Your ref: SSD 29999239  
File no: MC-21-00007

**SSD 29999239 – Rooty Hill Materials Recycling Facility**

# Blacktown Council's submission to SSD 29999239 - Rooty Hill Materials Recycling Facility

Found : T:\2021 Jobs\211274-600 Woodstock Av Glendening\Drawings\Civil\211274-CAD\01-DA\211274_DAC05.31.dwg

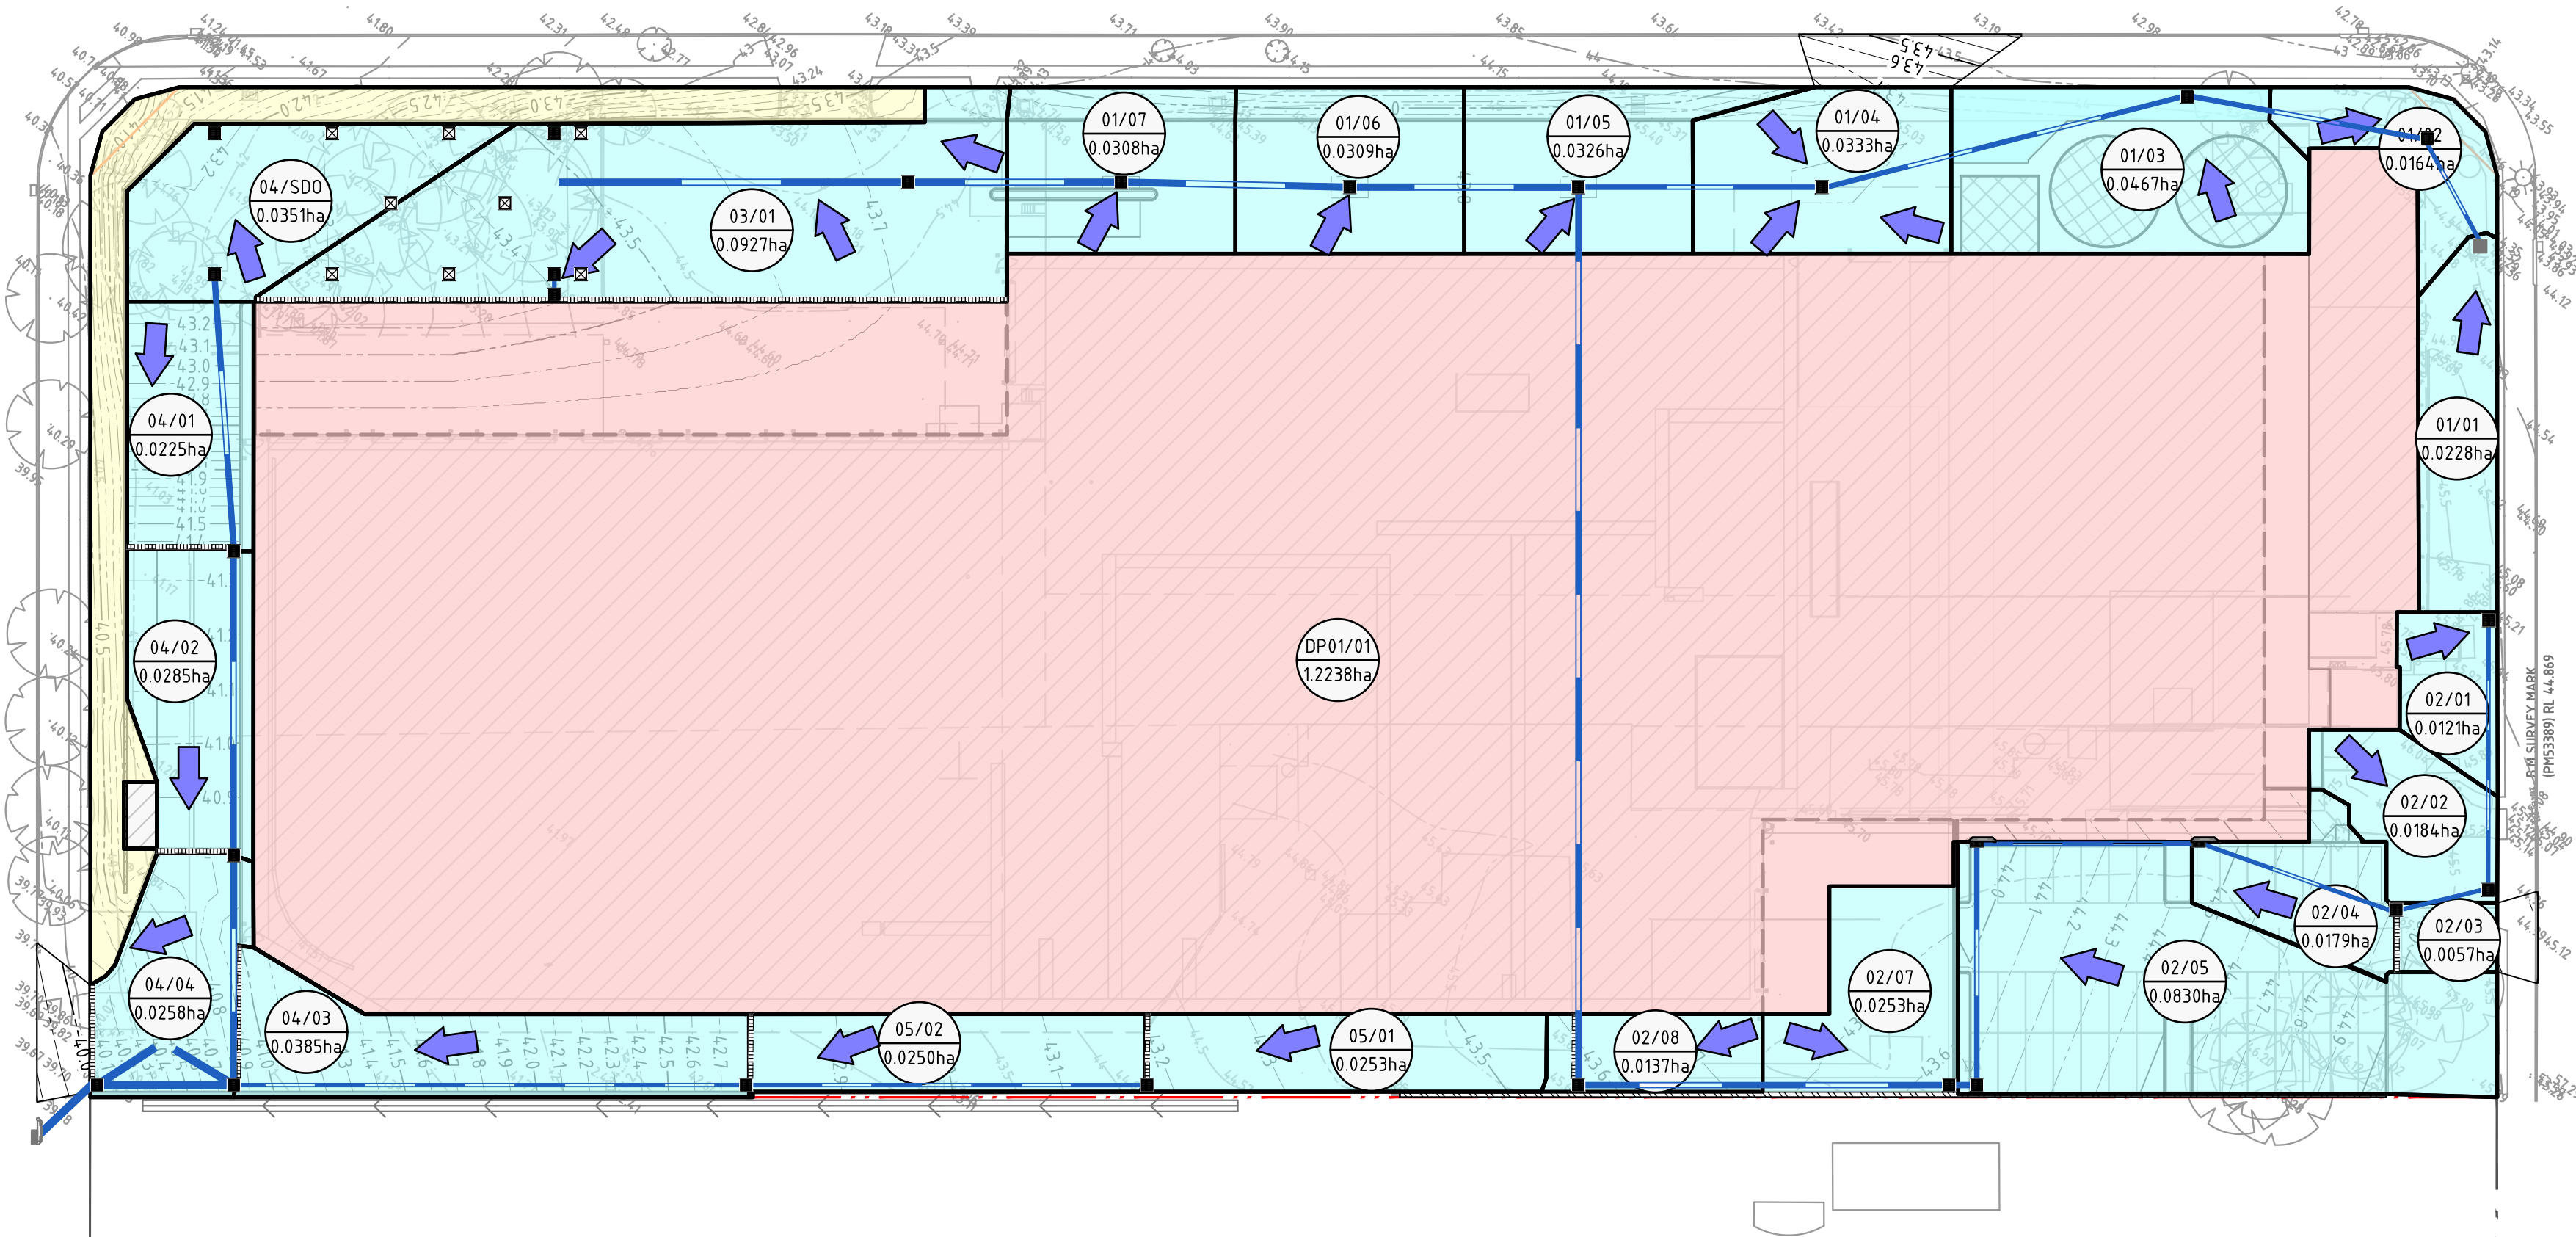
- h. Drawings DAC05.31 (02) and DAC05.32 (02):
- The lids for the On Site Detention tank are to be grated trafficable lids.
  - Rename 100 year Average Recurrence Interval to 1% Annual Exceedance Probability on all notes and plans.

- Rename 1.5 year Average Recurrence Interval to 50% Annual Exceedance Probability on all notes and plans.
  - Provide 2 x 600 x 1200 mm grates over the 1% Annual Exceedance Probability orifice control pit and overflow pit.

- Provide a 900 mm x 900 mm grate over the 50% Annual Exceedance Probability orifice.
  - The starting / lowest level in the base of the On Site Detention tank is to be the centreline of the 50% AEP orifice (1.5 year orifice) grading up at 2% from there.

- Provide separate orifice details for the 50% Annual Exceedance Probability orifice and 1% Annual Exceedance Probability orifice.
  - Provide a minimum 2% slope in the On Site Detention storage. For larger tanks this can be in the form of a 2% cross-slope to a central "V" drain with 2%

longitudinal slope along the “V” drain. Reassess tank dimensions to achieve the minimum storage volumes.

- The orifice within the Discharge Control Pit is to be protected by a suitable screen. Provide Maximesh Rh3030 for orifice diameters 150 mm or less with a minimum area of 50 times the orifice area and Weldlok F40/203 for orifices 150 mm diameter or more with a minimum area of 20 times the orifice area.

- Remove the rainwater tank weir and extend the wall to the soffit of the tank. Provide series of overflow pipes (i.e. 4 x 150 mm diameter) with non-return flaps.

- The outlet pipe from the On Site Detention tank must be sized to 1% Annual Exceedance Probability 5-minute storm event. Increase the pipe size accordingly.

- The sealed lid to the rainwater tank pump must have a minimum internal opening of 2 x 600 mm x 1200 mm to facilitate maintenance access to the pumps
